DEVELOPMENT REVIEW BOARD  
TRANSPORTATION DEVELOPMENT

DRB Project Number: 1011598  
Signal Village

SUBJECT: Sketch Plat

DRB Project Number: 1011598 Hearing Date: 4-18-2018

EXHIBIT "A"

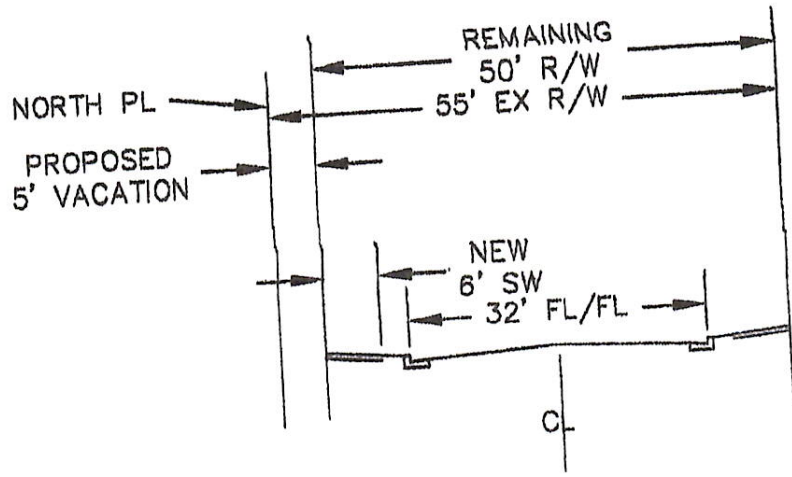
1. Provide a sidewalk exhibit showing the location, width, and defining the distance from back of curb to the property line. Right of way dedication may be required.
2. Follow DPM table 23.2.2 for private access road requirements.
3. For final plat, any access easements need to be shown with all beneficiaries and maintenance responsibilities listed.
4. Infrastructure is required for this request. Provide an Infrastructure list for approval.
5. Stub streets over 150' long need to have a vehicular turnaround (i.e. 96' cul-de-sac or 120' hammerhead)

PLAT OF  
**LOT 1 THRU 6**  
**SIGNAL VILLAGE**  
 WITHIN THE  
**ELENA GRANT**  
 PROJECTED SECTION 17  
 TOWNSHIP 11 NORTH, RANGE 4 EAST, N.M.P.M.  
 CITY OF ALBUQUERQUE  
 BERNALILLO COUNTY, NEW MEXICO  
 APRIL, 2018

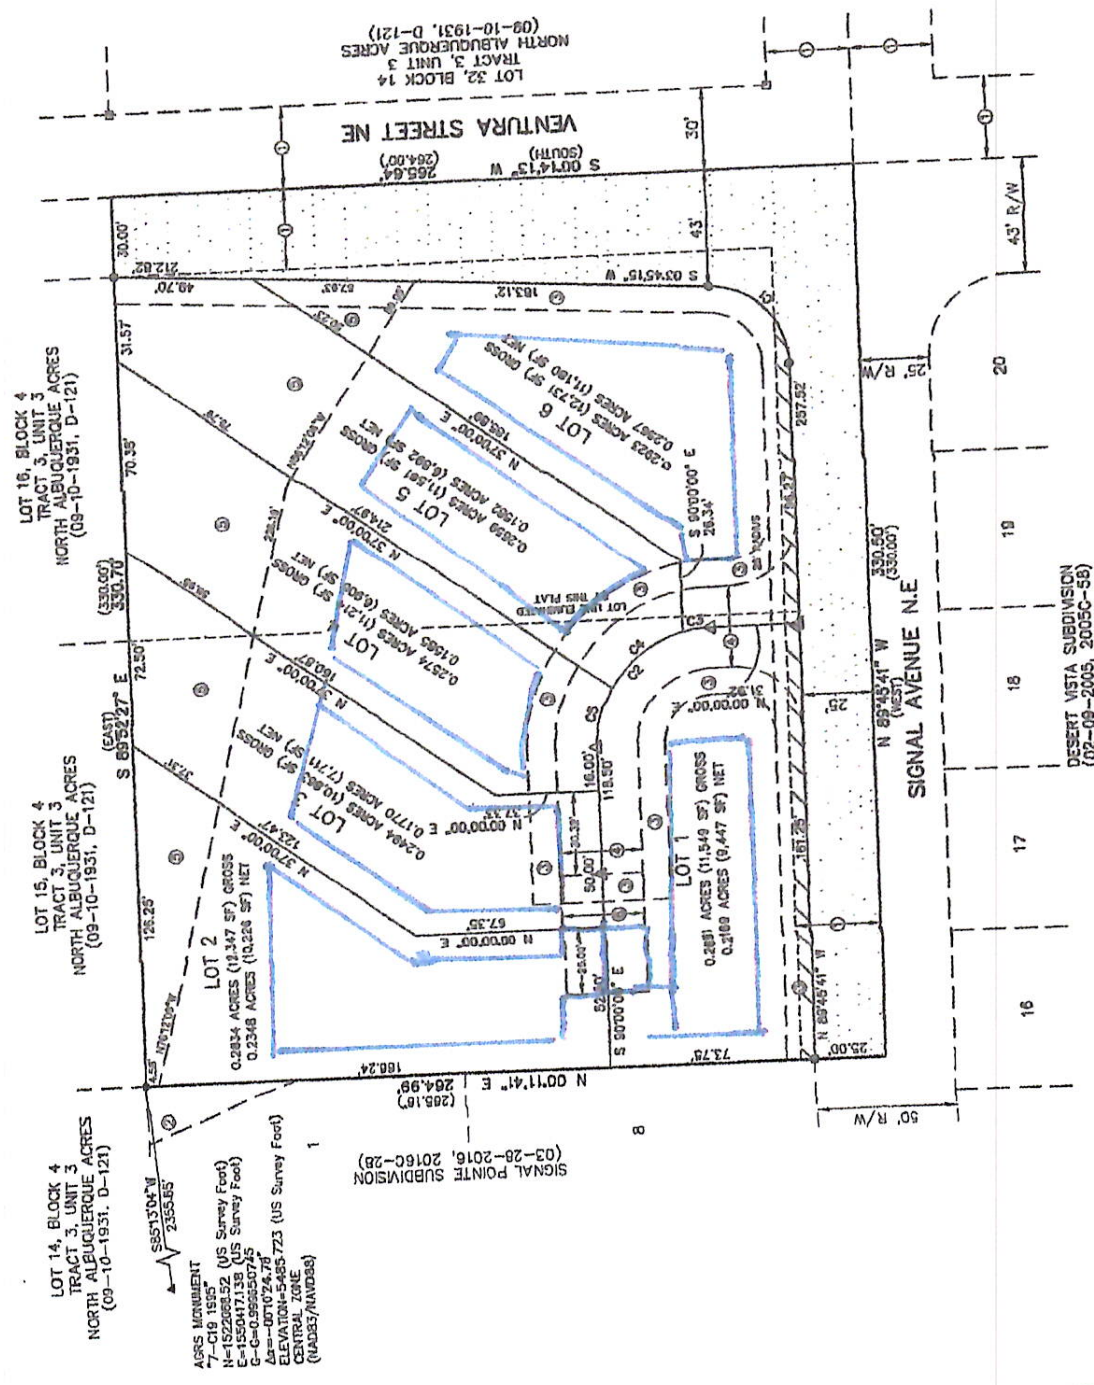
- An approved Drainage report is required prior to Preliminary Plat approval.
- A recorded SIA is required prior to Final Plat approval.
- A public drainage easement must be shown on both the preliminary and final plats to contain the floodplain.
- A Public Drainage Easement and an Agreement and Covenant must be recorded for the arroyo improvements prior to work order.
- Show the existing floodplain on both the Preliminary and Final Plat and include a reference to the source of the information and effective date.
- A LOMR must be received from FEMA removing the Floodplain Prior to issuance of any building permits.
